Project Title: Utility Trailer Sales **Building Permit #:** _____ **Hydrology File #:** _____

**RE: UTILITY TRAILER SALES
8201 DAYTONA RD NW
GRADING AND DRAINAGE PLAN
ENGINEERS STAMP DATE: 3/27/18
HYDROLOGY FILE: K09D026B**

Please find the following responses addressing your comments listed below:

ENGINEER'S SEAL	UTILITY TRAILER SALES ALBUQUURQUE NM	DRAWN BY LA
		DATE 4/20/2018
	GRADING AND DRAINAGE PLAN	2017041—GRADING
	VINCENT P. CARRICA P.E. #16212	 <i>TIERRA WEST, LLC</i> 5571 MIDWAY PARK PLACE NE ALBUQUERQUE, NM 87109 (505) 858-3100 www.tierrawestllc.com
		JOB # 2017041

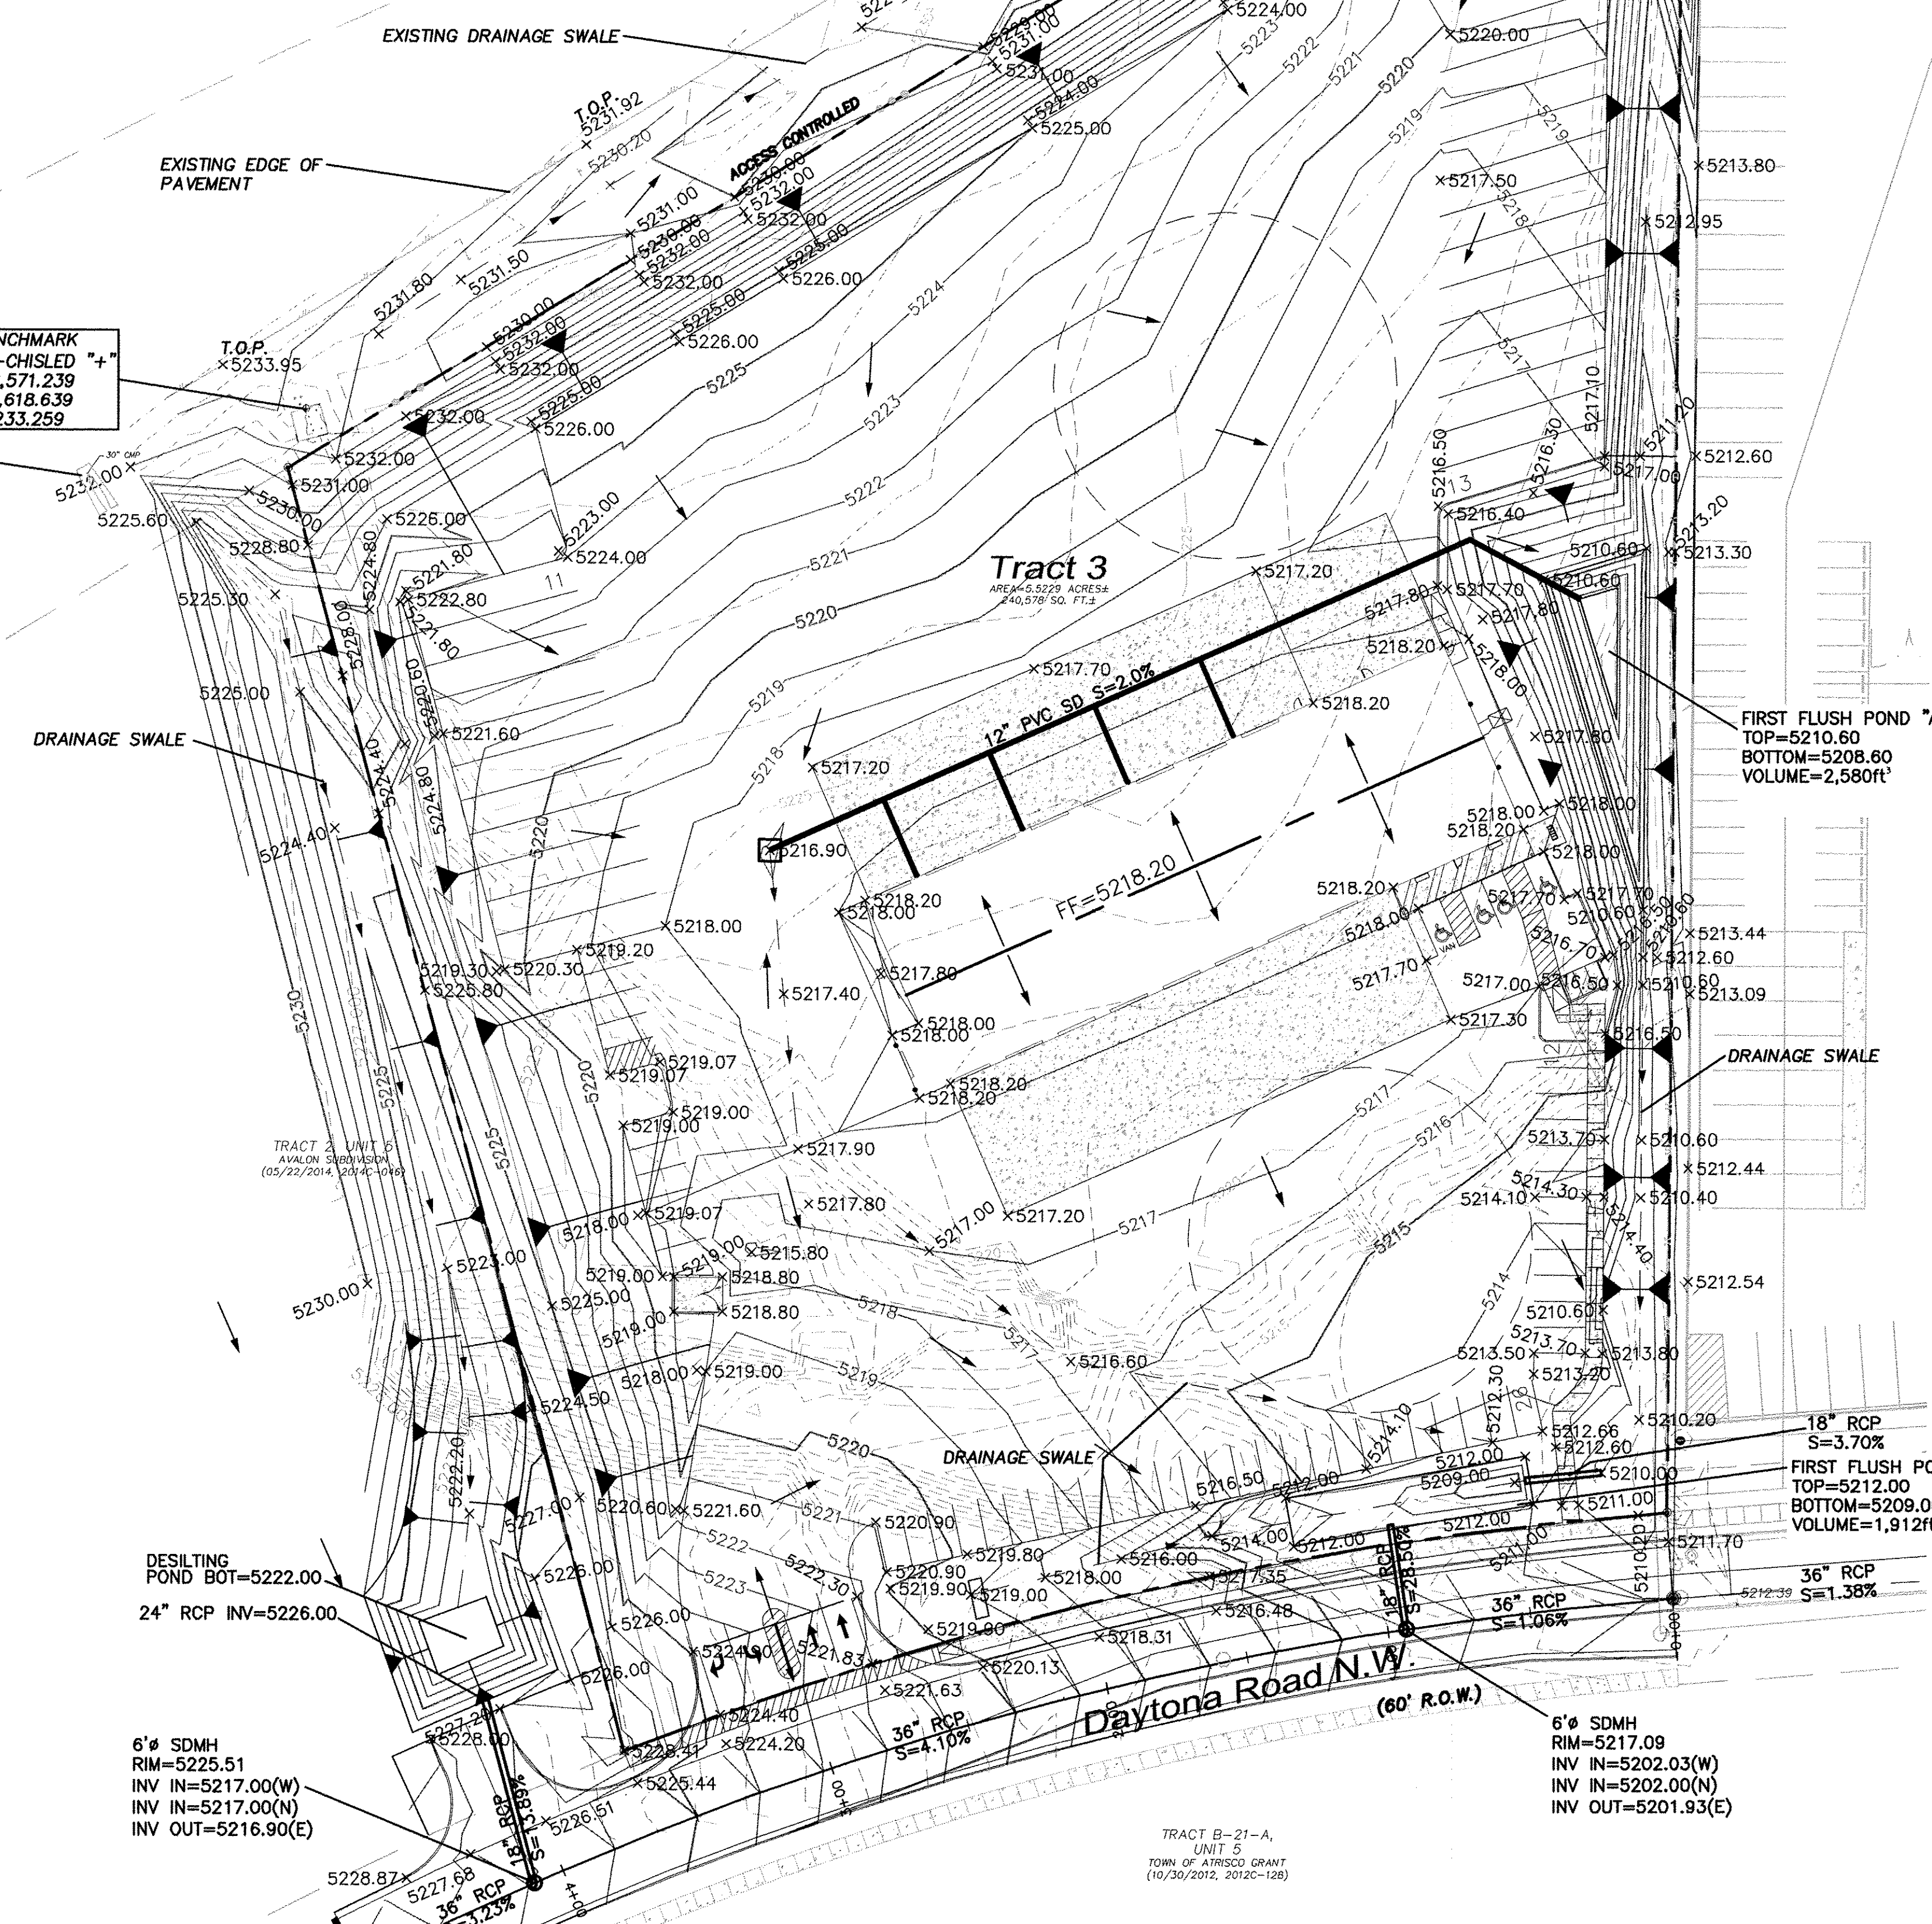
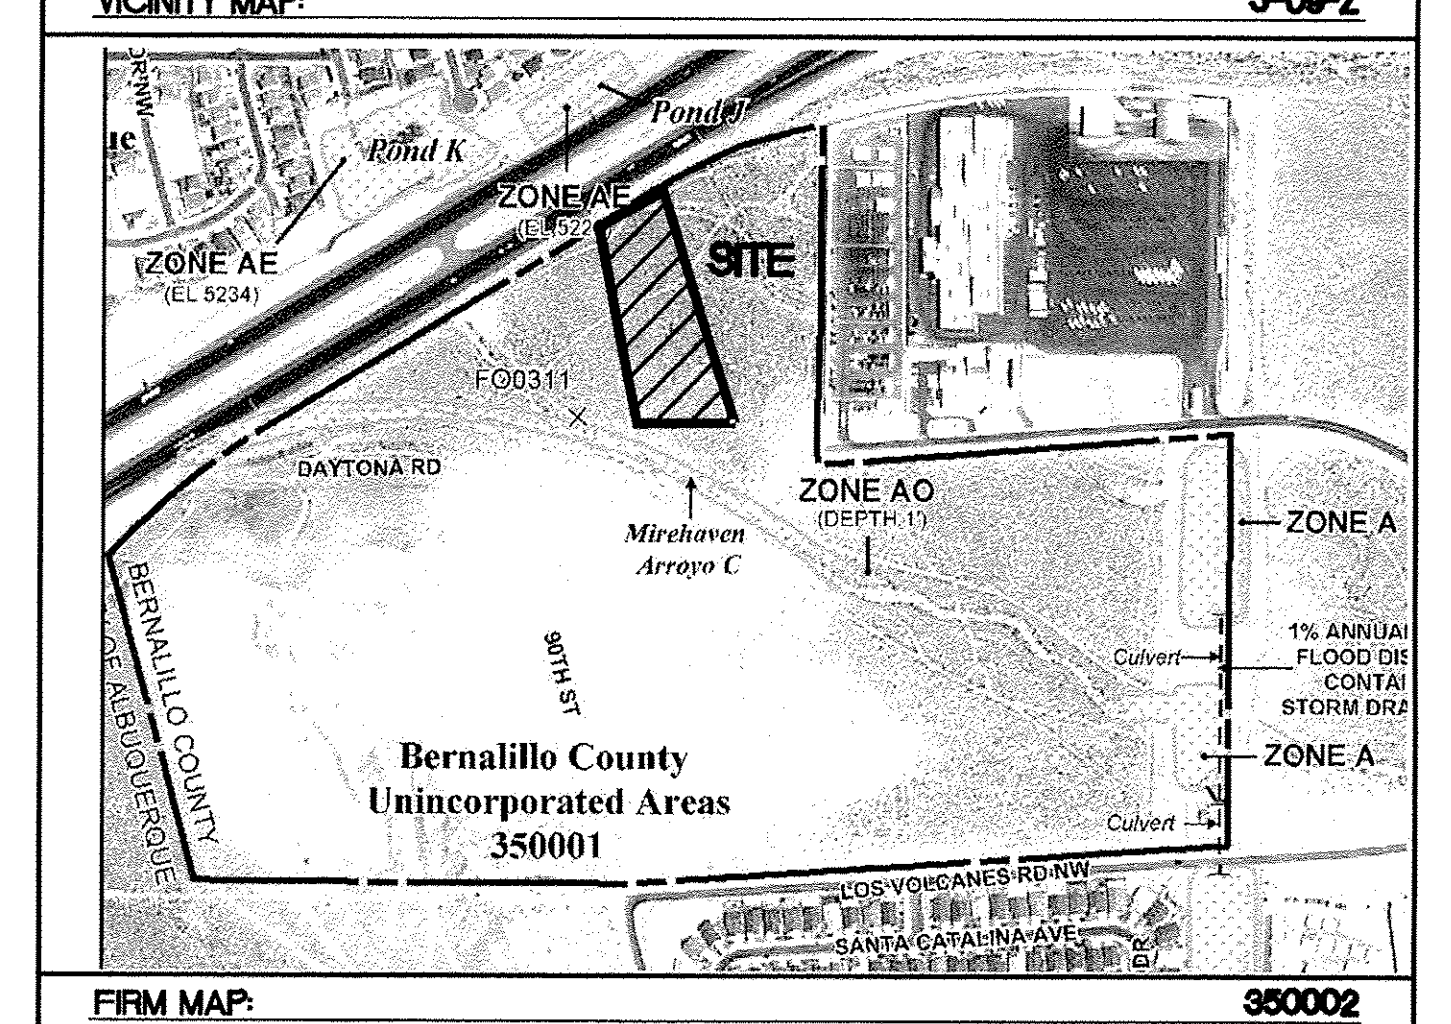
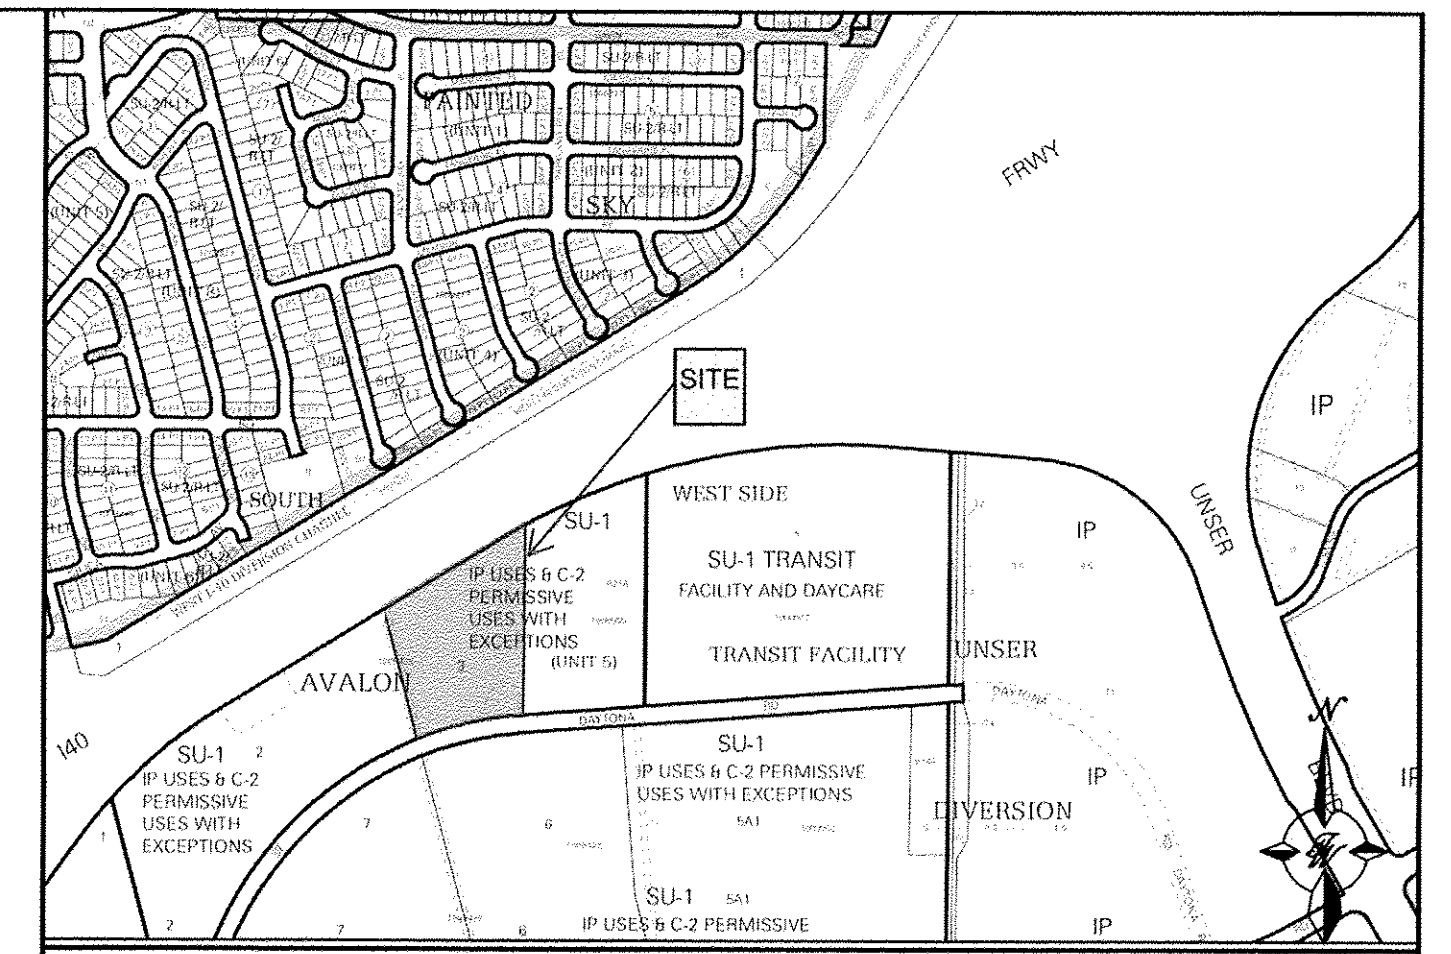
5. Clearly show on plans the limits of construction, areas of new impervious, existing and proposed topo.

7. The grading plan needs to be stamped.

8. Include project benchmark and datum.

Response: Plans have been modified to clearly identify construction and impervious areas. Existing contours were also added to the plan.

Response: The grading plan is stamped and signed.

Response: A benchmark and datum was added to the plan.
